**KIRKLEES METROPOLITAN COUNCIL
INVESTMENT & REGENERATION SERVICE**

Reference No:	2025/62/92403/E
Site Address:	8, Carr Side Crescent, Batley, WF17 7JN
Description:	Erection of single storey front extension with part single storey and two storey rear extension
Recommending Officer:	Edward Cheseldine

HOUSEHOLDER DELEGATED REPORT

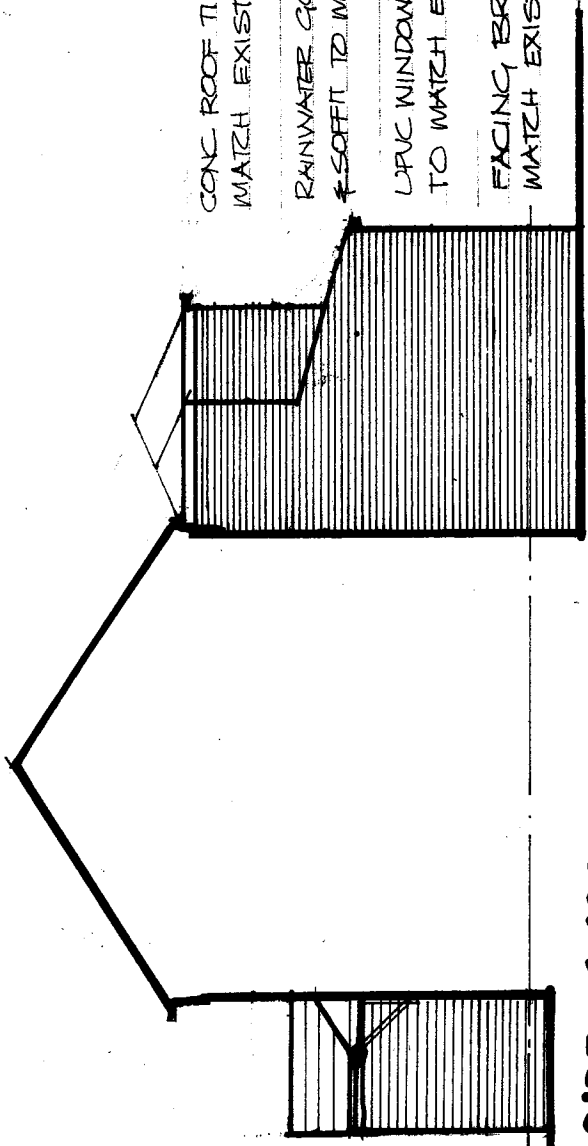
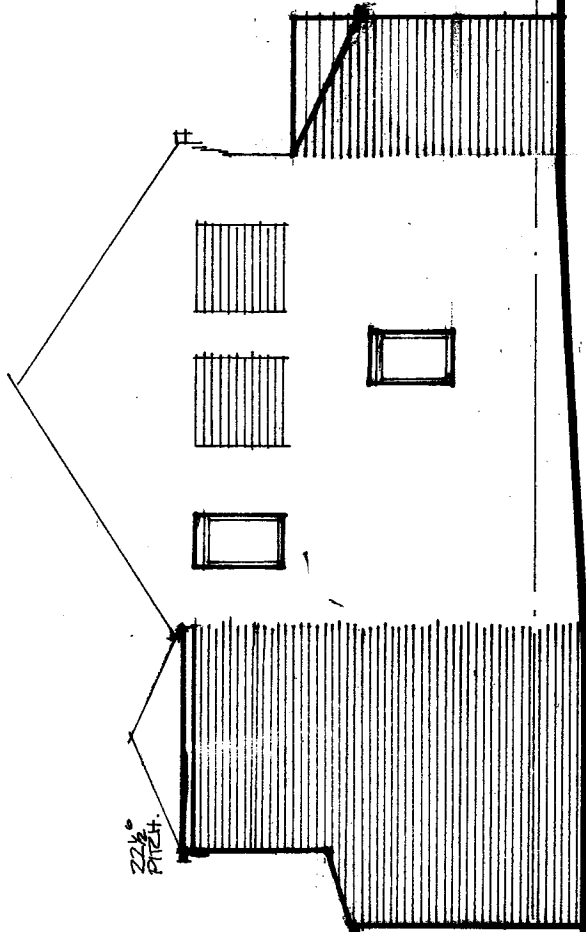
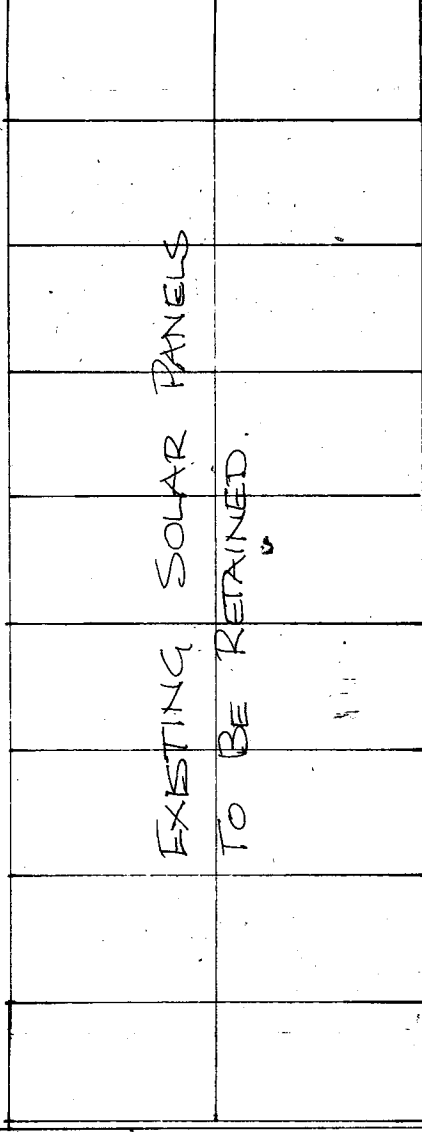
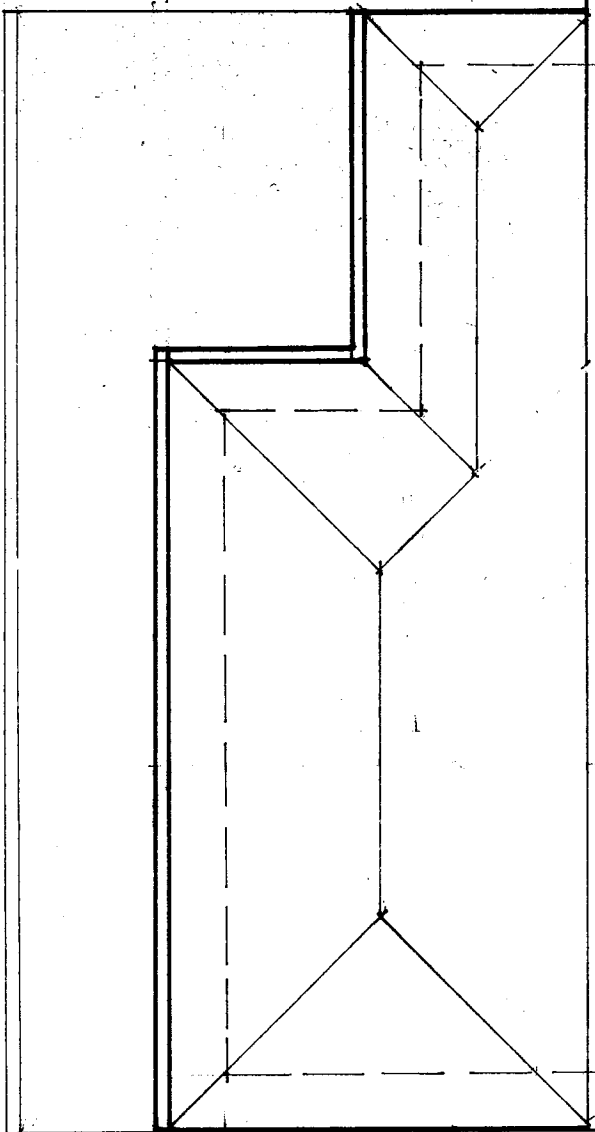
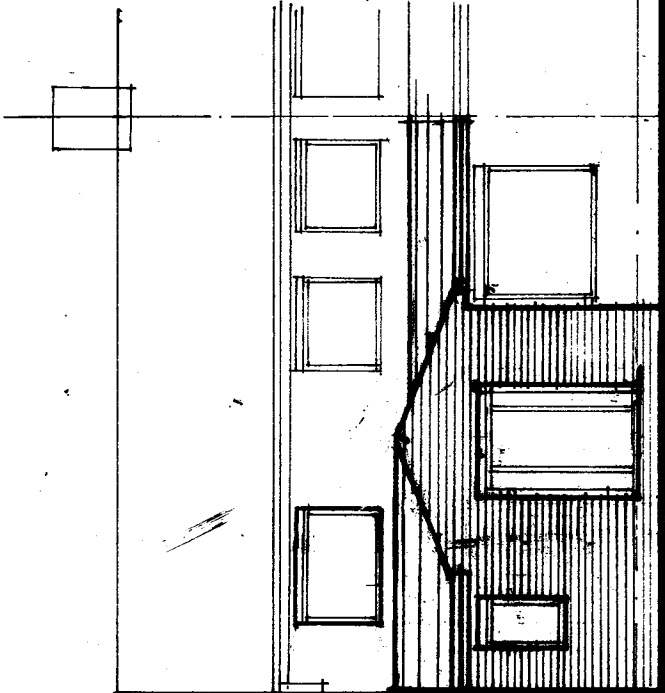
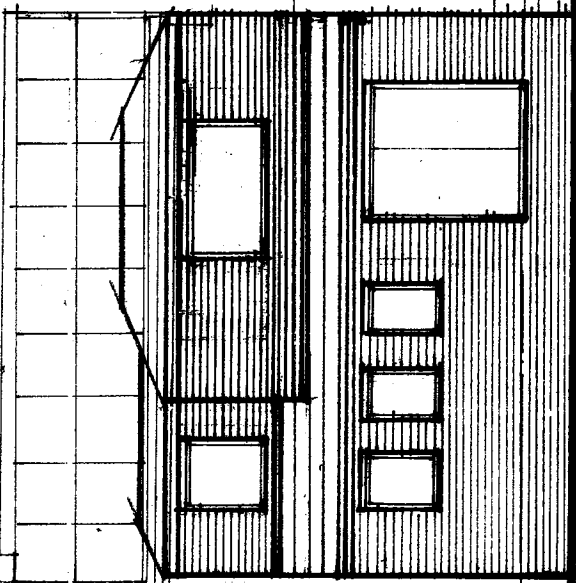
YES / NO	SUMMARY
Negotiations/Amendments during course of application	Yes	It was requested a roof was installed on the rear extension to preserve the amenity of the streetscene due to the visibility of the side elevation. Amended plans were submitted included a floating pitched roof which was accepted.

It was requested a roof was installed on the rear extension to preserve the amenity of the streetscene. Amended plans were submitted included a floating pitched roof which was accepted.

4. The window openings of the development shall be in accordance with those detailed within submitted drawing reference 8CSCB/03 revA. The window openings shall be thereafter retained and maintained for the lifetime of the development in accordance with the details upon 8CSCB/03 revA.
